PLANNING CONSULTATION RESPONSE

Application No	2026/0084
Proposal	Conversion of 2no. residential flats back into 1no. 4 bed dwellinghouse
Address	35 Huddersfield Road, Barnsley, S75 1DN
Date of Consultation Reply	18/02/26
Consultee	Highways DC

SITE PLAN
Scale 1:200

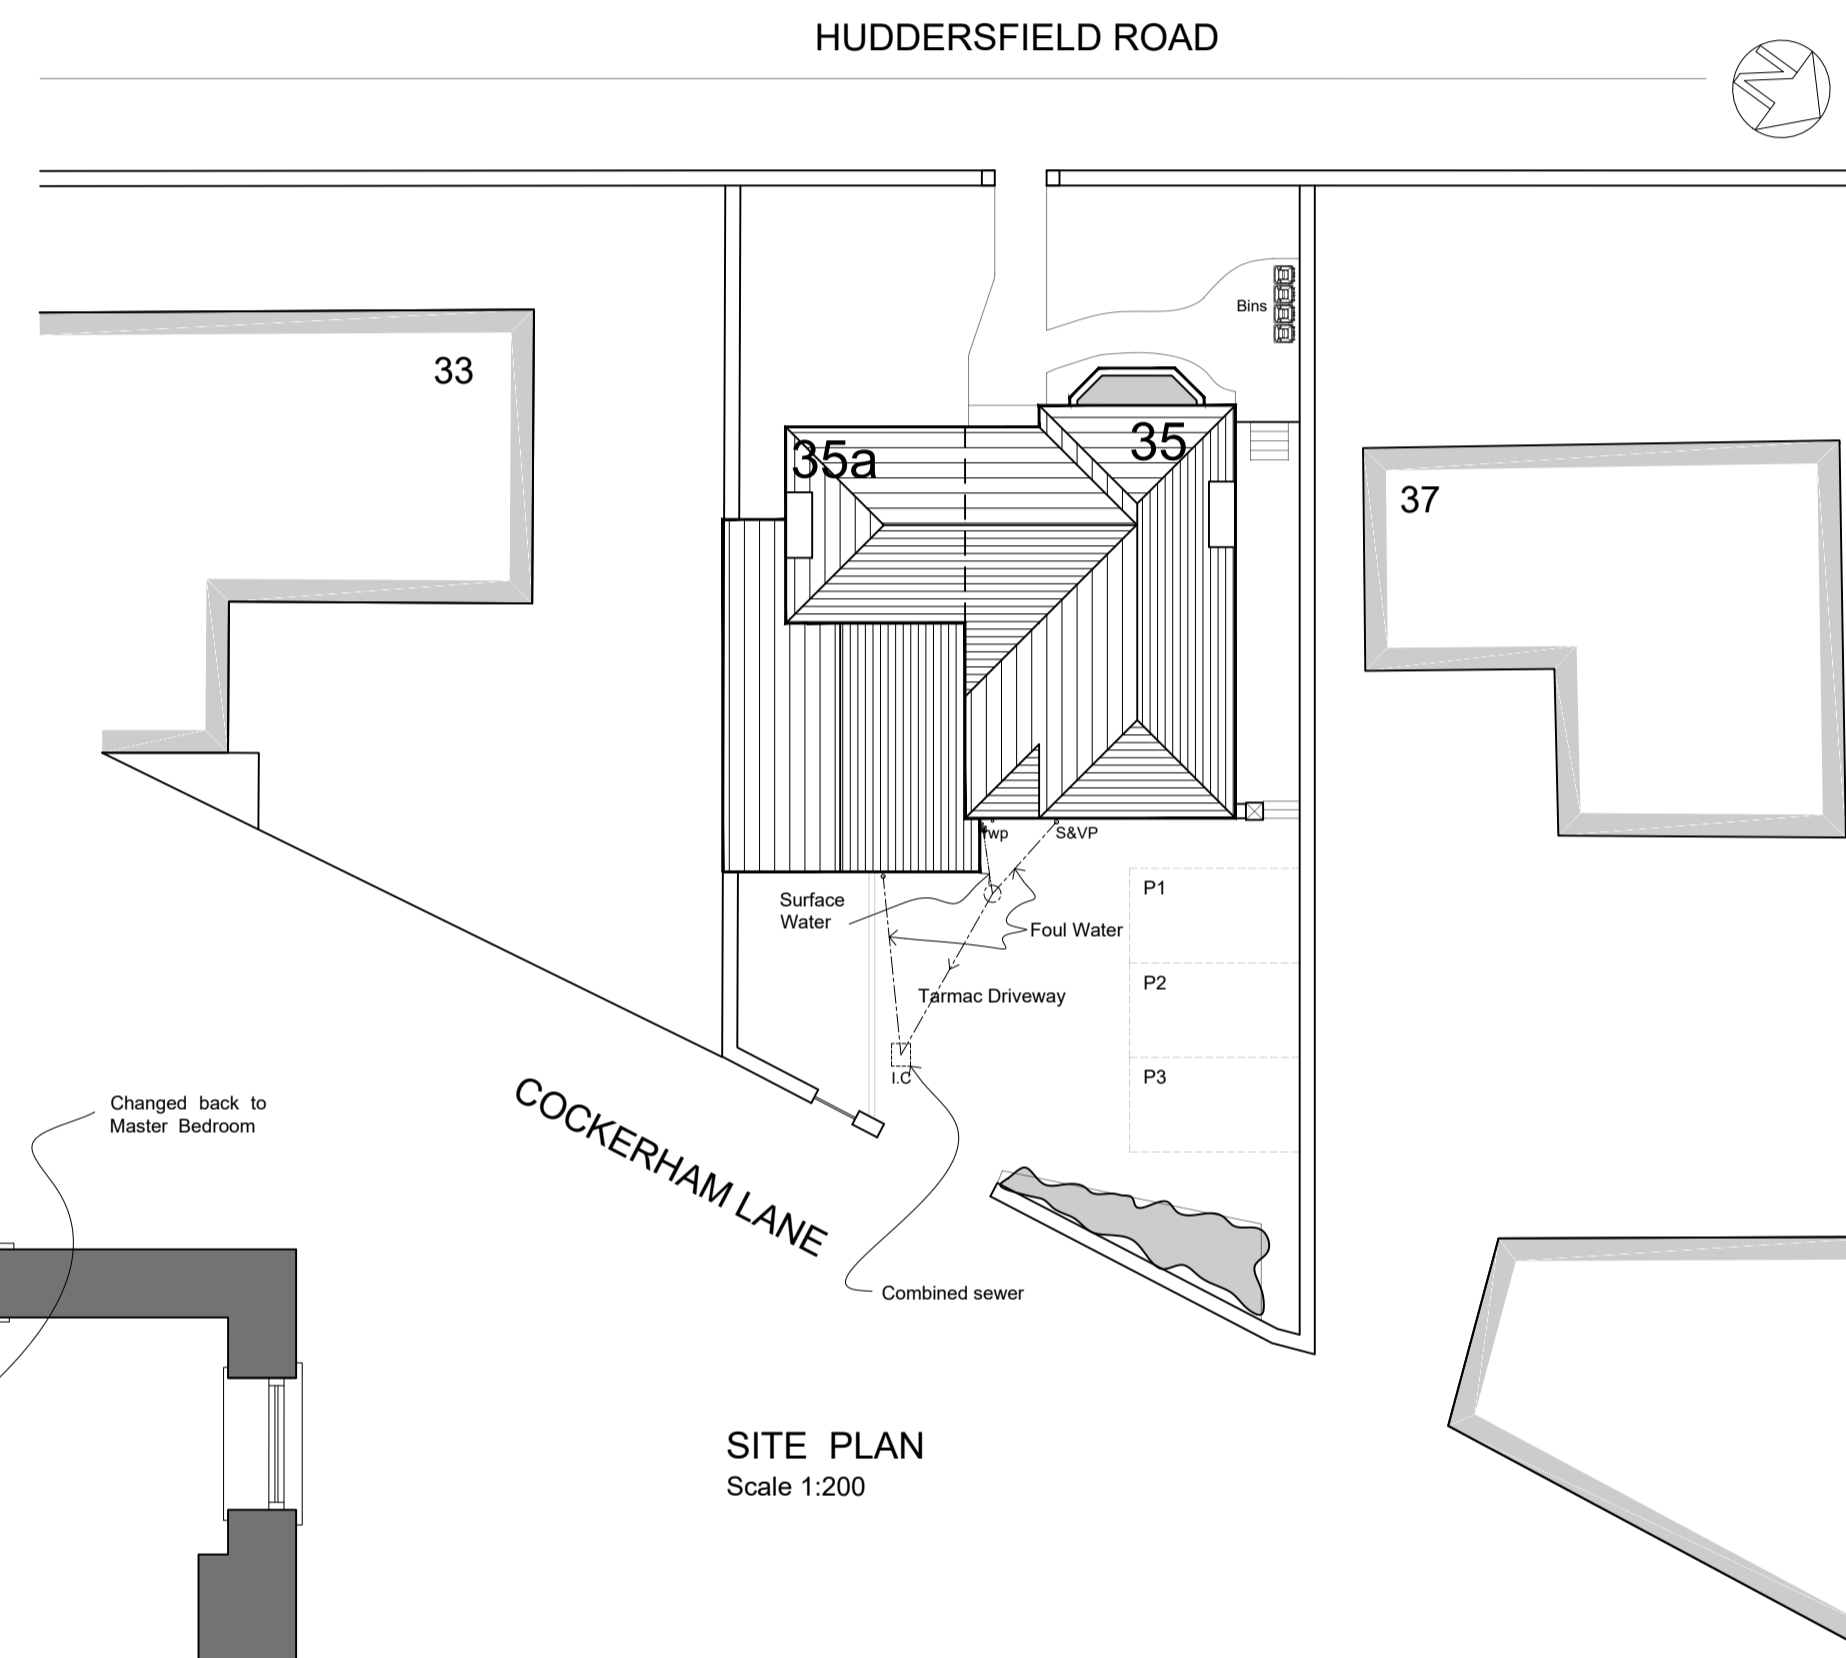
The Council's Parking SPD recommends one parking space per flat and also recommends two parking spaces per dwelling of three bedrooms or more.

As such, the site retains the expected off-street parking provision with the submitted layout showing a driveway able to accommodate three vehicles. It is likely that deliveries and bin storage requirements would diminish following the proposed change. As such, HDC officers would have no wish to raise objection to the scheme.
